KITTITAS COUNTY

MEMORANDUM

TO: All Staff
FROM: Public Works Plan Review Team
DATE: July 6, 2026
SUBJECT: SP-26-00005 Ridgway

# RIDGWAY SHORT PLAT PART OF SECTION 29, T. 18 N., R. 19 E., W.M. KITTITAS COUNTY, WASHINGTON

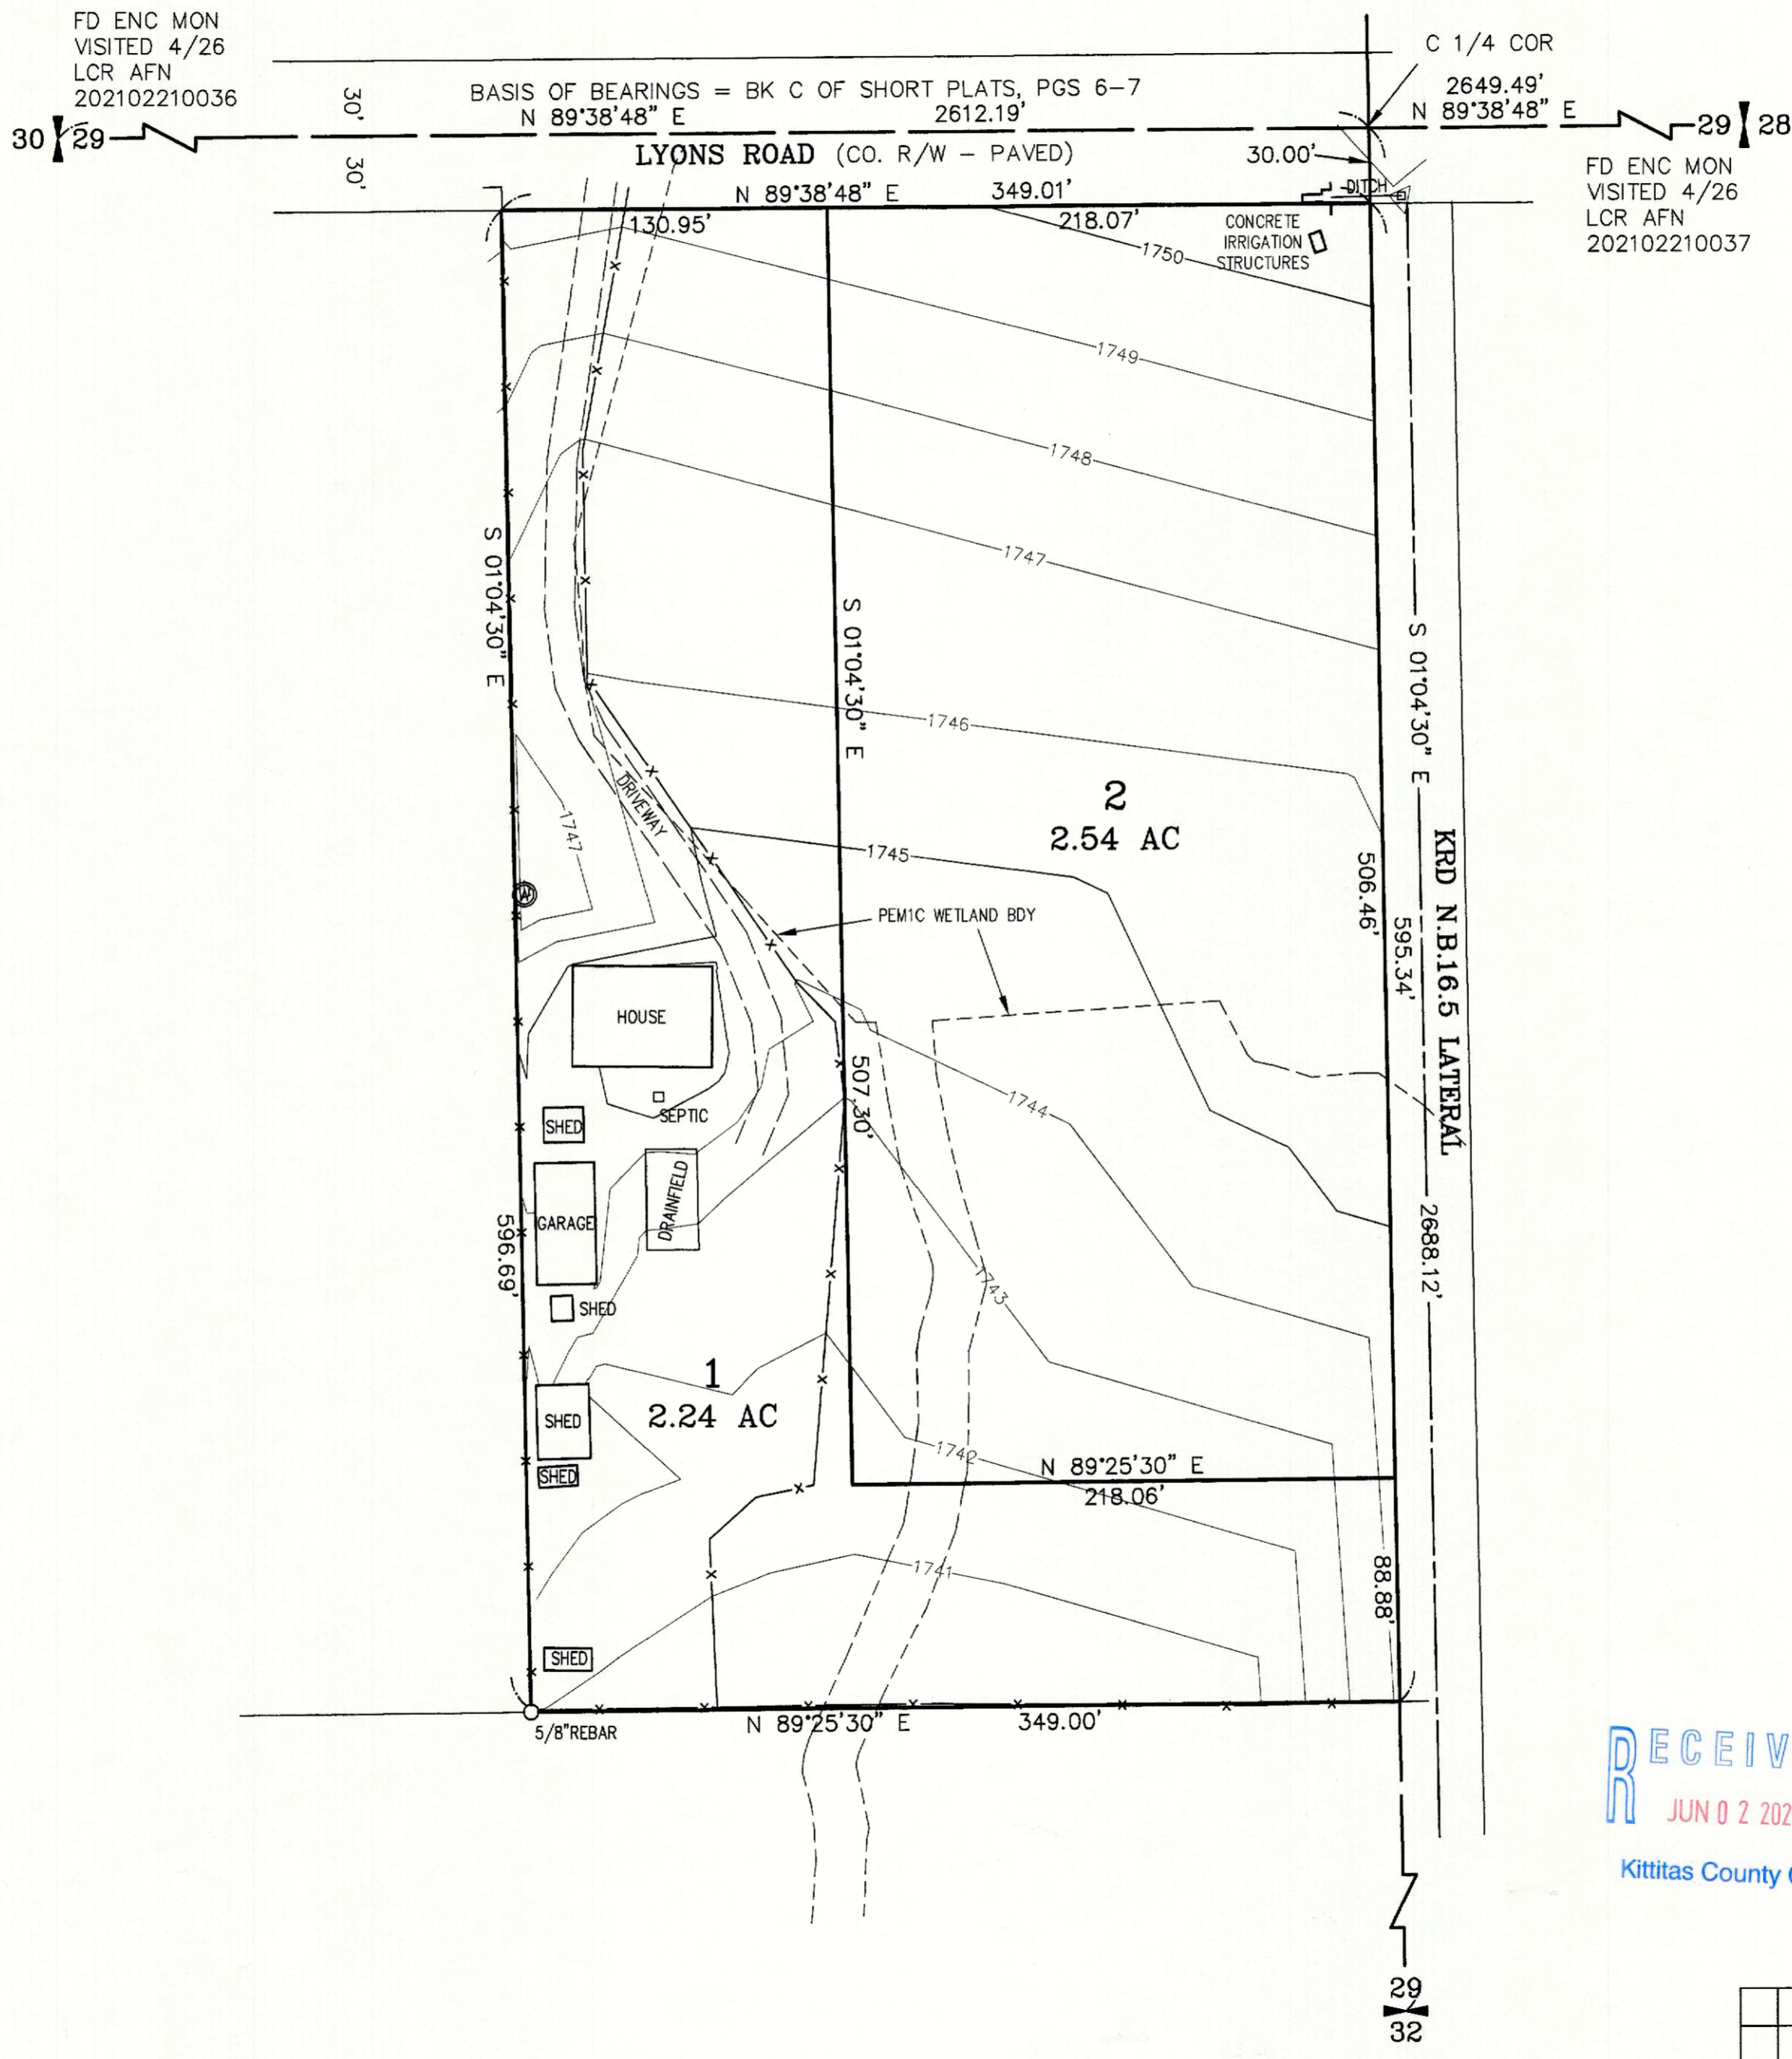
ENGINEERING	Except as exempted in KCC 14.05.060, no grading or filling upon a site involving more than one hundred (100) cubic yards shall be performed without a grading permit from the County Engineer or Public Works designee (KCC 14.05.050). An application for grading in excess of five hundred (500) cubic yards shall be accompanied by an engineered grading plan (KCC 14.05.080). (CBP)
SURVEY	1. Lot closures were not provided. Due to simple nature of division, Lot Closures are not required. 2. Title report not provided. Title report will need to be reviewed prior to final approval. This may trigger additional survey requirements. 3. There appear to be problems with the existing legal description. This will be reviewed when Title Report is received. Incorrectly labelled as 'Dedication'. 4. Note 3 needs recording information. 5. The S1/4 cor of Section shown is missing a label and description. 6. As a minimum, the new division line will need to have corners shown and set in the field. 7. Per aerial images, it appears that there may be usage/trespass along the east line of the subject property. This should be shown and noted.

8. The name of the Short Plat must be unique. 9. Include building offsets from property lines. (JT)
TRANSPORTATION CONCURRENCY	Not required for this project. (RC)
FLOOD	Parcel # 636636 is not mapped within a FEMA identified special flood hazard area (1% annual chance flood zone). Floodplain development permitting is not required for the proposed project. (SC)
WATER MITIGATION/ METERING	The following comments outline the requirements for legal availability of water and metering for the proposed short plat: The applicant must provide legal water availability for all new uses on the proposed lots of this project. Prior to final plat approval and recording, the following conditions shall be met: In accordance with KCC Chapter 13.35.027, the applicant shall provide one of the following documents before final plat approval: 1. A letter from a water purveyor stating that the purveyor has adequate water rights and will provide the necessary water for the new use; 2. An adequate water right for the proposed new use; or 3. A certificate of water budget neutrality from the Department of Ecology or other adequate interest in water rights from a water bank. All applicants for land divisions shall also submit information on "proximate parcels" held in "common ownership" as those terms are defined in WAC 173-539A-030 and otherwise demonstrate how the proposed new use will not violate RCW 90.44.050 as currently existing or hereafter amended. Failure to obtain mitigation before commencement of an activity requiring mitigation shall be a code violation subject to enforcement under Title 18 KCC. Final Plat Notes The following notes shall be placed on the face of the plat: C-1 "Metering is required for all new uses of domestic water for residential well connections and usage must be recorded in a manner consistent with Kittitas County Code Chapter 13.35.027 and Ecology regulations." C-2 "The approval of this division of land provides no guarantee that use of water under the ground water exemption (RCW 90.44.050) for this plat or
